9 December 2022

Our ref: *D2022/164830*

Shoalhaven Hydro Expansion Project - Main Works – EIS Review (SSI-10033)

ATTACHMENT 1 – WATERNSW COMMENTS – SHOALHAVEN PUMPED HYDRO EXPANSION PROJECT EIS (CSSI-10033)

Figure 1-1 Project location

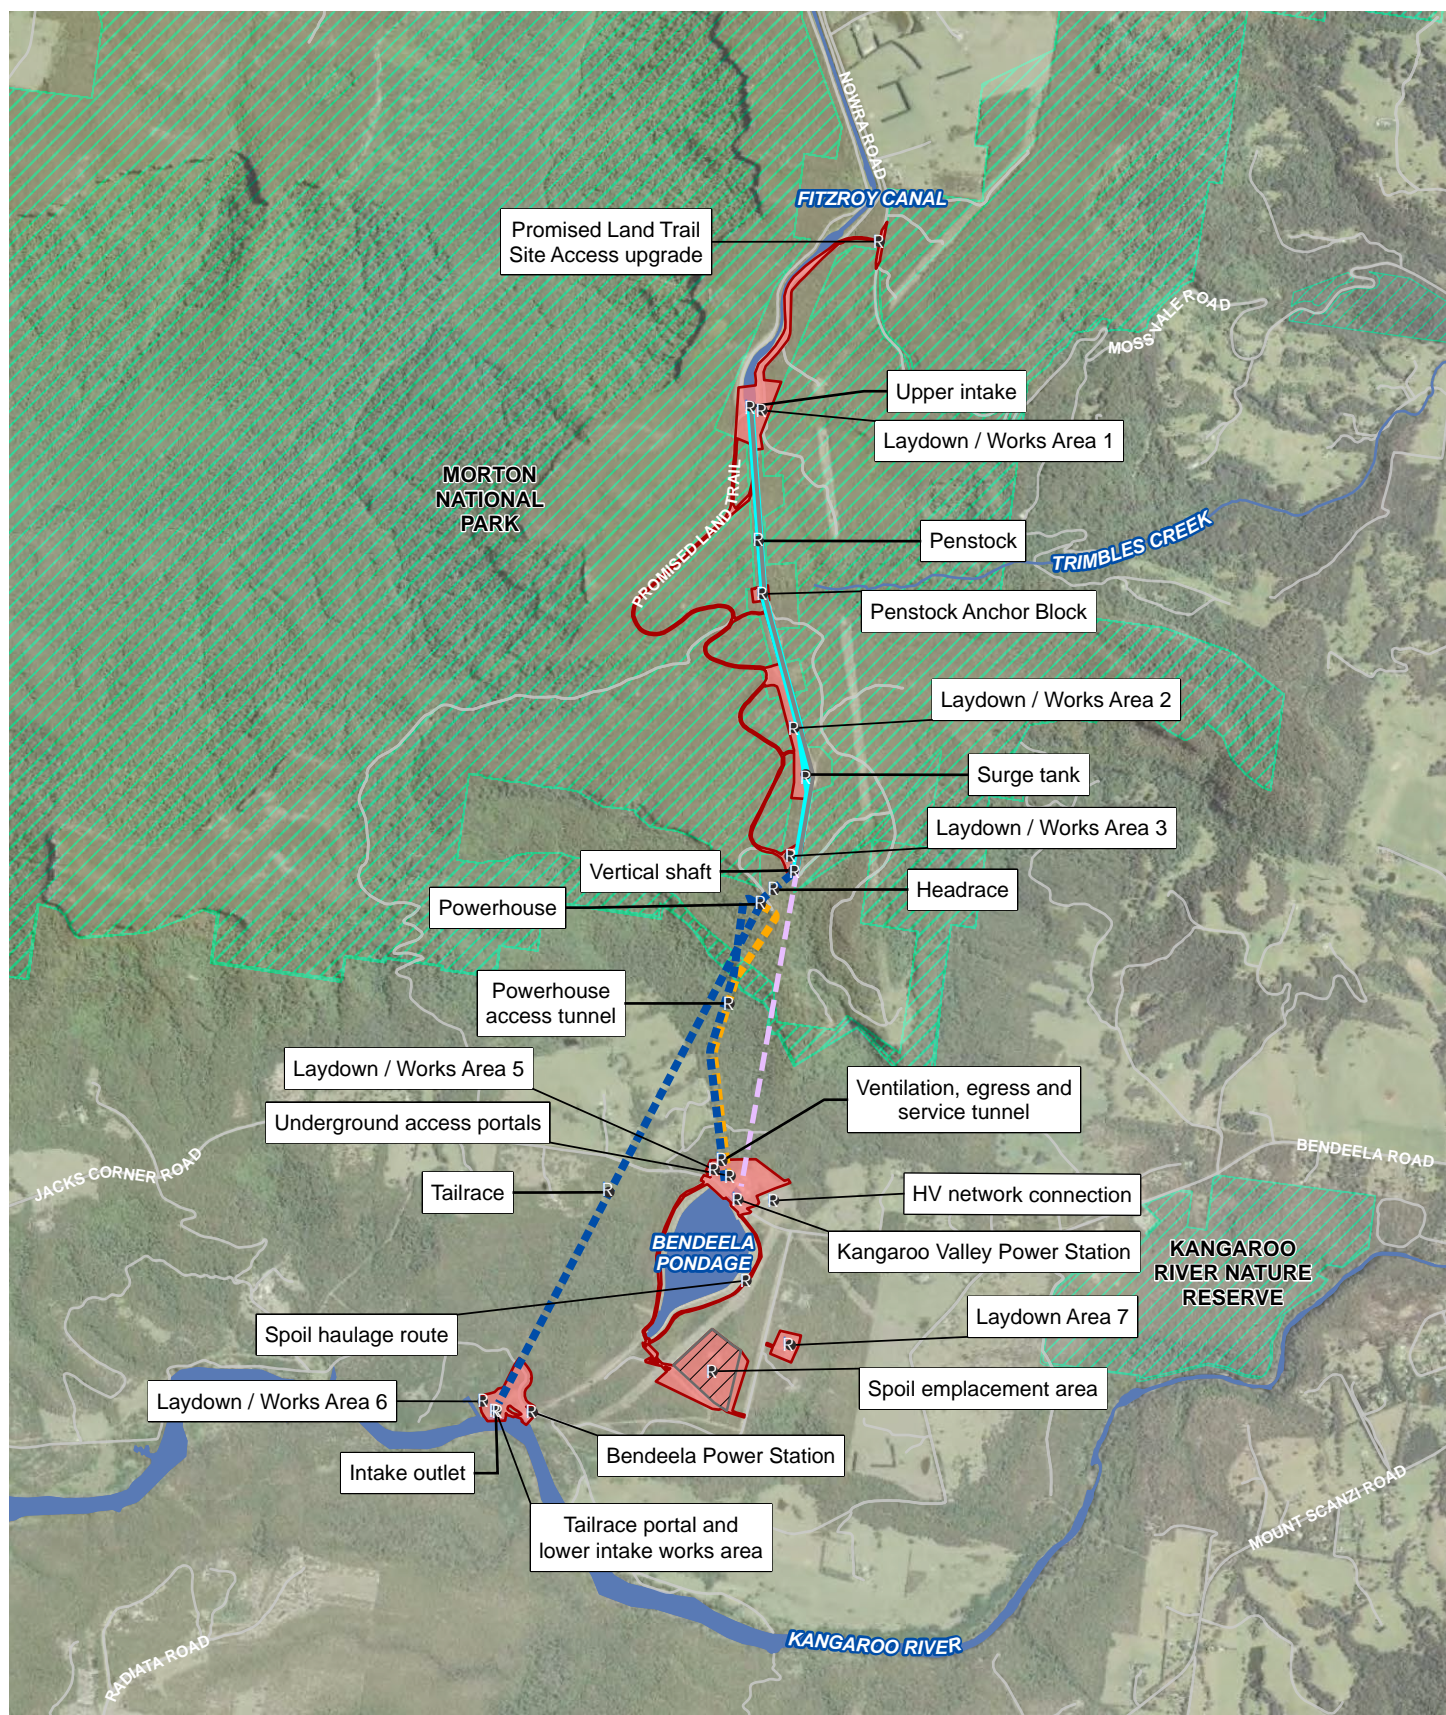
Bushfire Appendix O - Bushfire Assessment	<p>General</p> <ul style="list-style-type: none"> - The bushfire safety report and delivery of bushfire safety for the site is hindered by the fact that the description of the works on page 1 do not relate well to the location of works depicted on Figure 1-1. Many of the proposed works, such as tunnels, are provided as indicative locations or are missing from Figure 1-1. This problem then carries across to the risk assessment and mitigation measures put forward in Table 4-2 of the report, making it very difficult to reconcile whether bushfire safety considerations have been addressed for all aspects of the activity. (Project Overview; p.1) provides a detailed description of the key project components (Upper scheme works, underground works, lower scheme surface components). Many of the descriptors used are not carried across to Figure 1-1 and the project works being described differently on the Figure, with many of the works not being presented. This makes it very difficult to reconcile what works are occurring where. Ideally Figure 1-1 should depict the location of the works described on page 1 using the same descriptors provided on page 1. That said, the works described on page 1 are generally mostly catered for in the bushfire risk and mitigation analysis provided for the project 	<ul style="list-style-type: none"> • That further clarity is required around the project elements and the location and nature of the safety measures that will be adopted to protect people and property. • For buildings in isolated or critical areas, the project must demonstrate how it can deliver for special fire protection purpose equivalent outcomes for building/ staff protection and meet evacuation requirements.

TITLE UPPER INTAKE GATE AND TRASHRACK		
SCALE AS SHOWN	DRAWING No IA193700-0200-CI-DRG-001	REV B

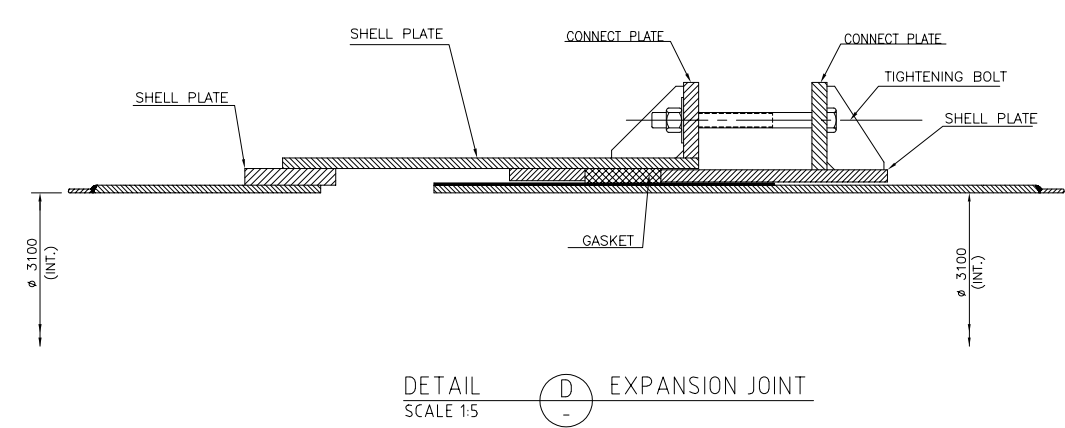
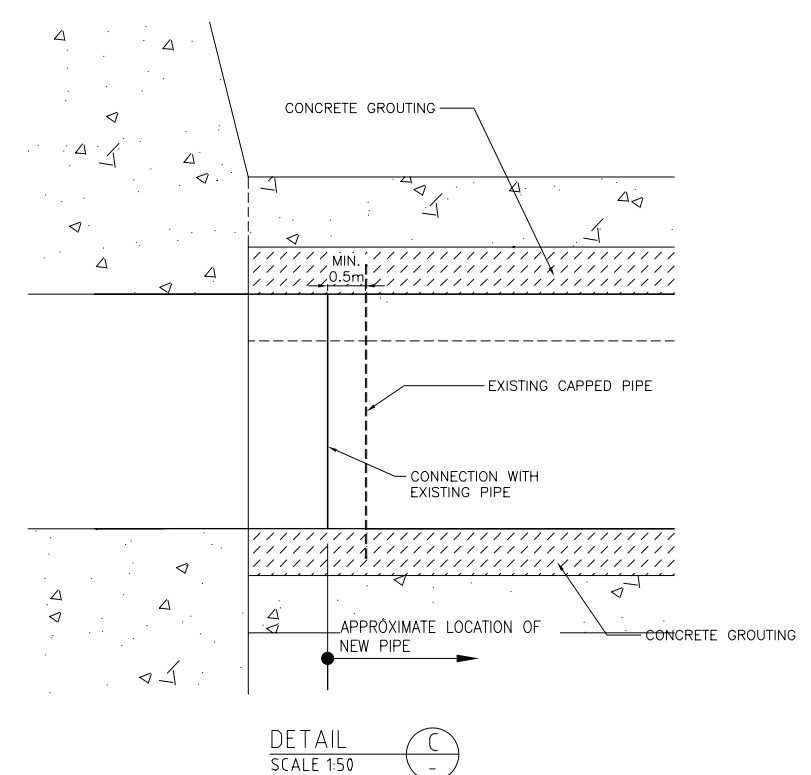
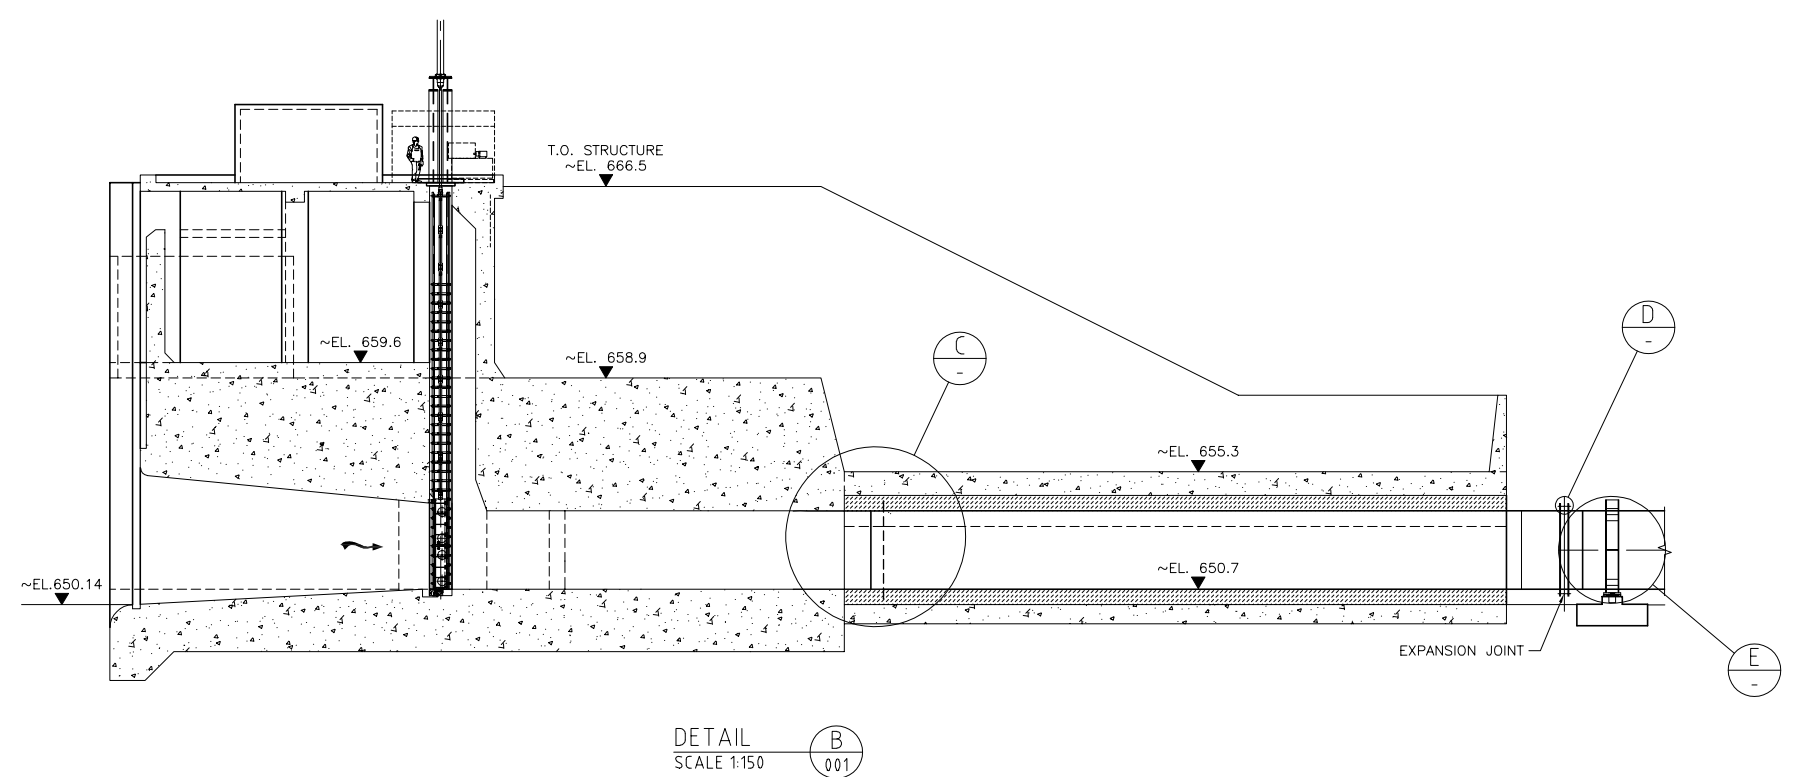
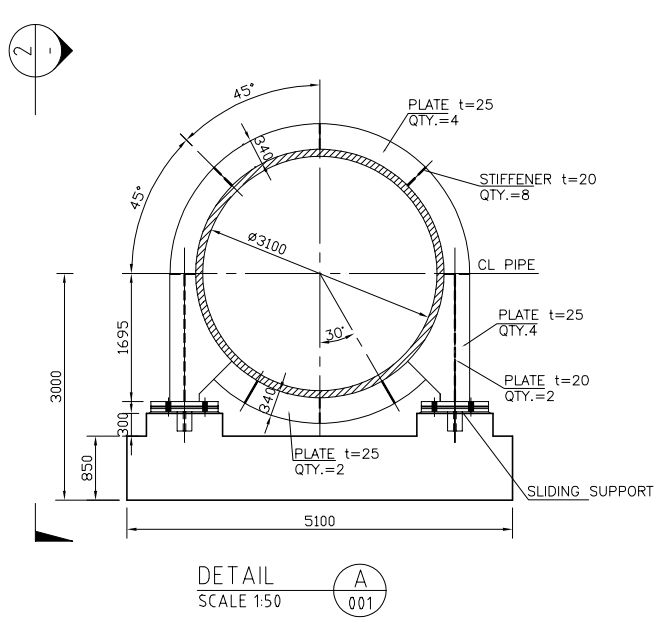
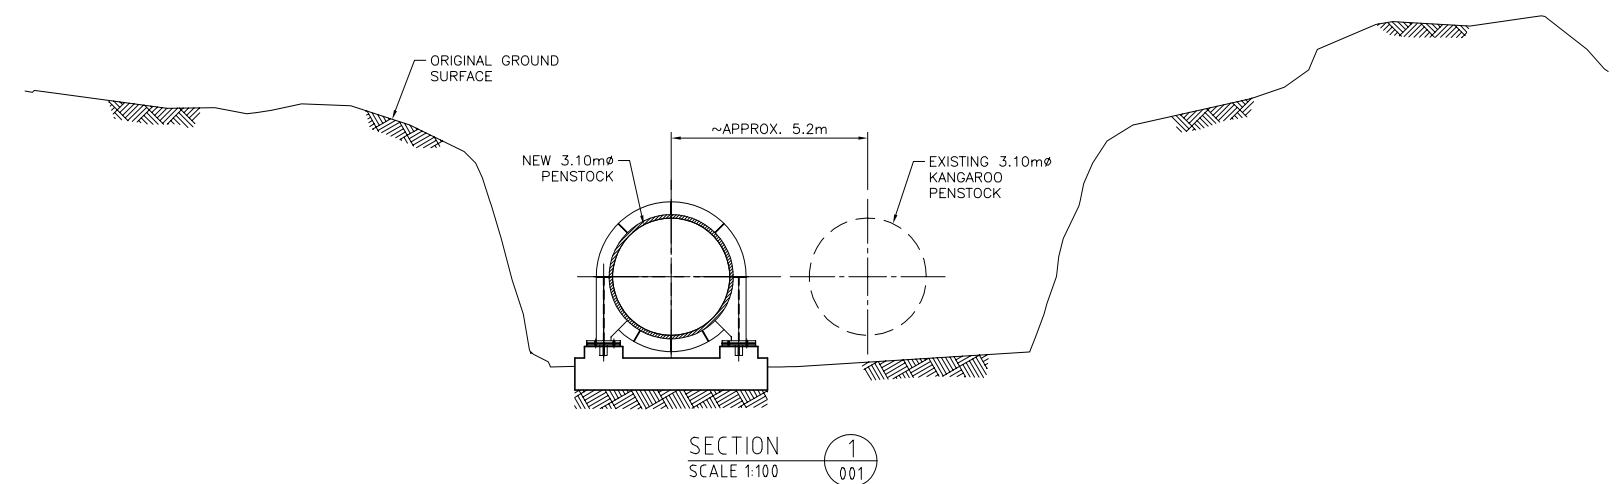
Key Issue Area	WaterNSW comment	Recommendation
General	<p>EIS - 3.3.1 – Project Components - Fitzroy Canal - The EIS refers to new penstock connection to the existing intake control structure. Clarification is required regarding arrangements between the new penstock connection, new control gate and the trash rack to be installed in the existing structure (as shown on concept drawings).</p> <p>EIS – 4.1 – Table 4.1 – <i>Dam Safety Act 2015</i> – It must be noted by the proponent that the existing control gate is subject to dam safety requirements, therefore any changes to the control gate structure to accommodate the expanded scheme will also be subject to <i>Dam Safety Act 2015</i> requirements.</p> <p>Mitigation Measures (Appendix E) – In general the mitigation measures proposed address the generic impacts and safeguards required for the construction of projects of this magnitude. However, WaterNSW believe that site specific mitigations are lacking, that address the potential impact to the environment, lands and the community from construction through to operation. Where a known or potential Project impact is identified, there must be a corresponding safeguard to mitigate the impact.</p>	<ul style="list-style-type: none"> • Further explanation be provided to EIS section 3.3.1 • That additional Dam Safety Act requirements be included for consideration. • That further consideration be given to include site specific mitigation actions to mitigate potential or known impacts.
